**GALES-KINGSCLIFF PTY LTD**

19 May 2021

**Re: Submission for Proposed Hanson Tweed Sand Plant Expansion (SSD-10398)**

Figure 3.2 Local Catchment Map and Flow Paths – Existing Case

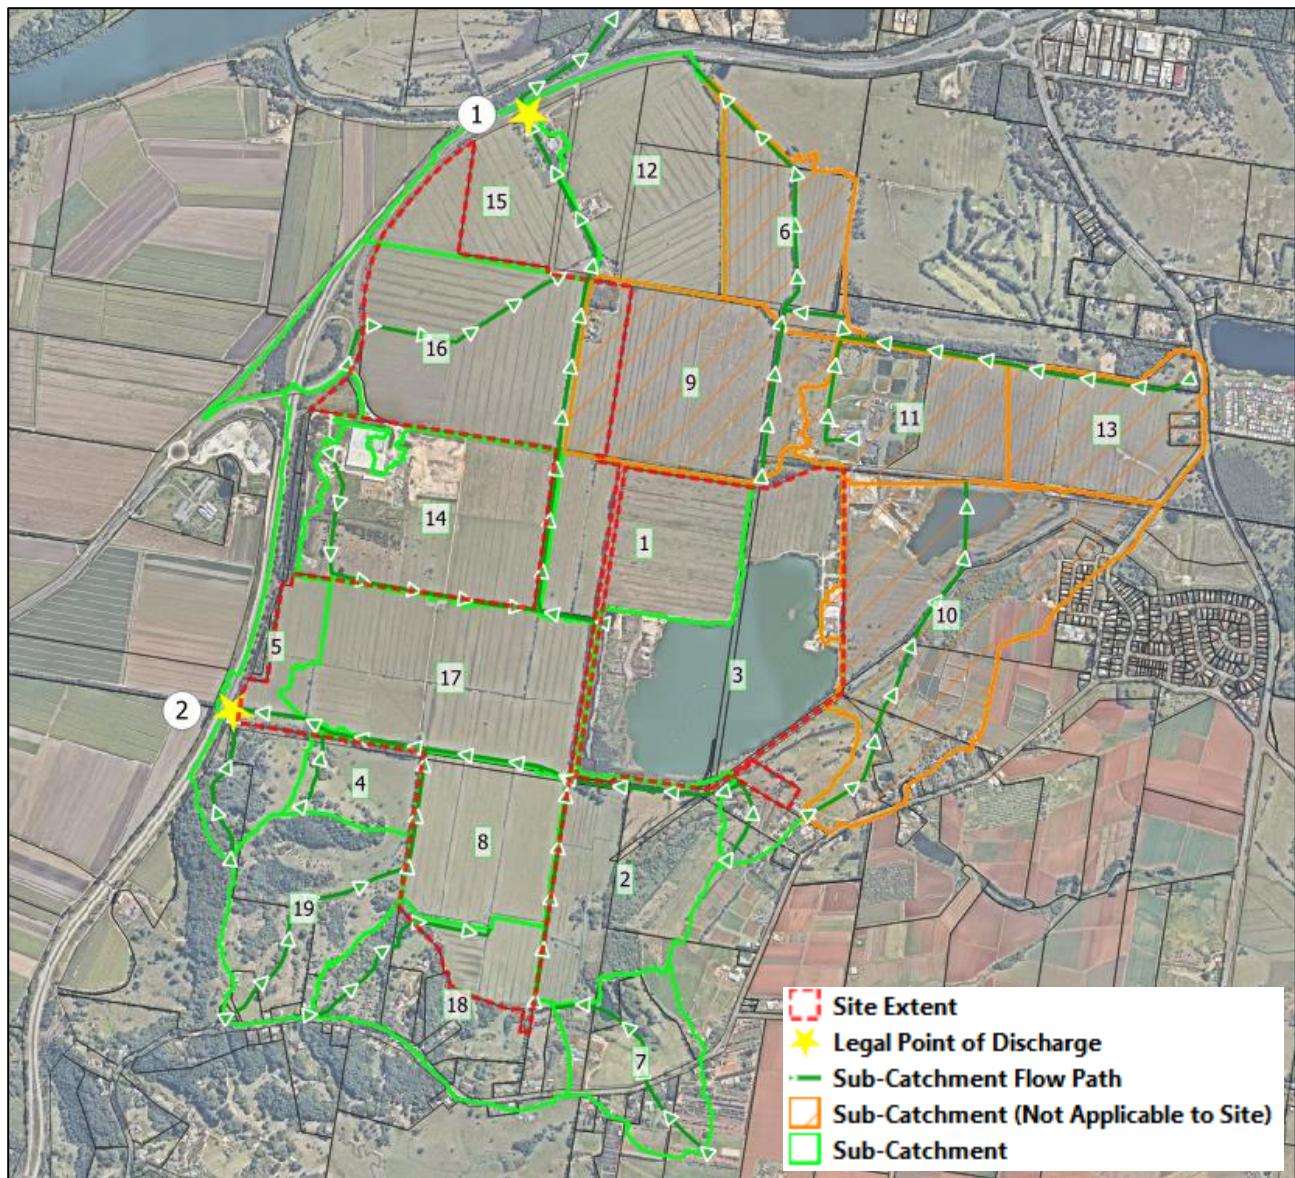
We believe that the depiction of the stormwater and agricultural drainage system within the EIS and supporting Flood & Stormwater Report (Burchills, 2021) is erroneous. Specifically on Figures 3.2 and 3.3 of Burchills (2021) report the drain along the south-east part of the existing Quarry lake is not shown as a drain and Catchment 10 shows flow from Cudgen Plateau draining towards the east and north across bunded areas of CLSQ rather than to this unmarked drain. This is incorrect and is inconsistent with previous correspondence between Hanson and Gales regarding inundation of Gales lands caused by blockage in the agricultural drainage system impeding drainage from CLSQ to the west and contributing to wetting up of Gales land to the east of the blockage.

- The assessment has not properly defined the external catchment influencing flood levels at the site (Figure 3.2). A local catchment flood assessment of the broader area undertaken for Gales by Venant Solutions established that during a 1% AEP event the drain along Altona Road flows from east to west towards the Hanson site. Further, this drain receives runoff from the catchment to the east of Tweed Coast Road.

**It is requested that the Burchill (2021) Flood & Stormwater Report be revised to account for the correct existing drainage, the blocked drains preventing flow west, and the impact of Hanson’s proposed changes.**
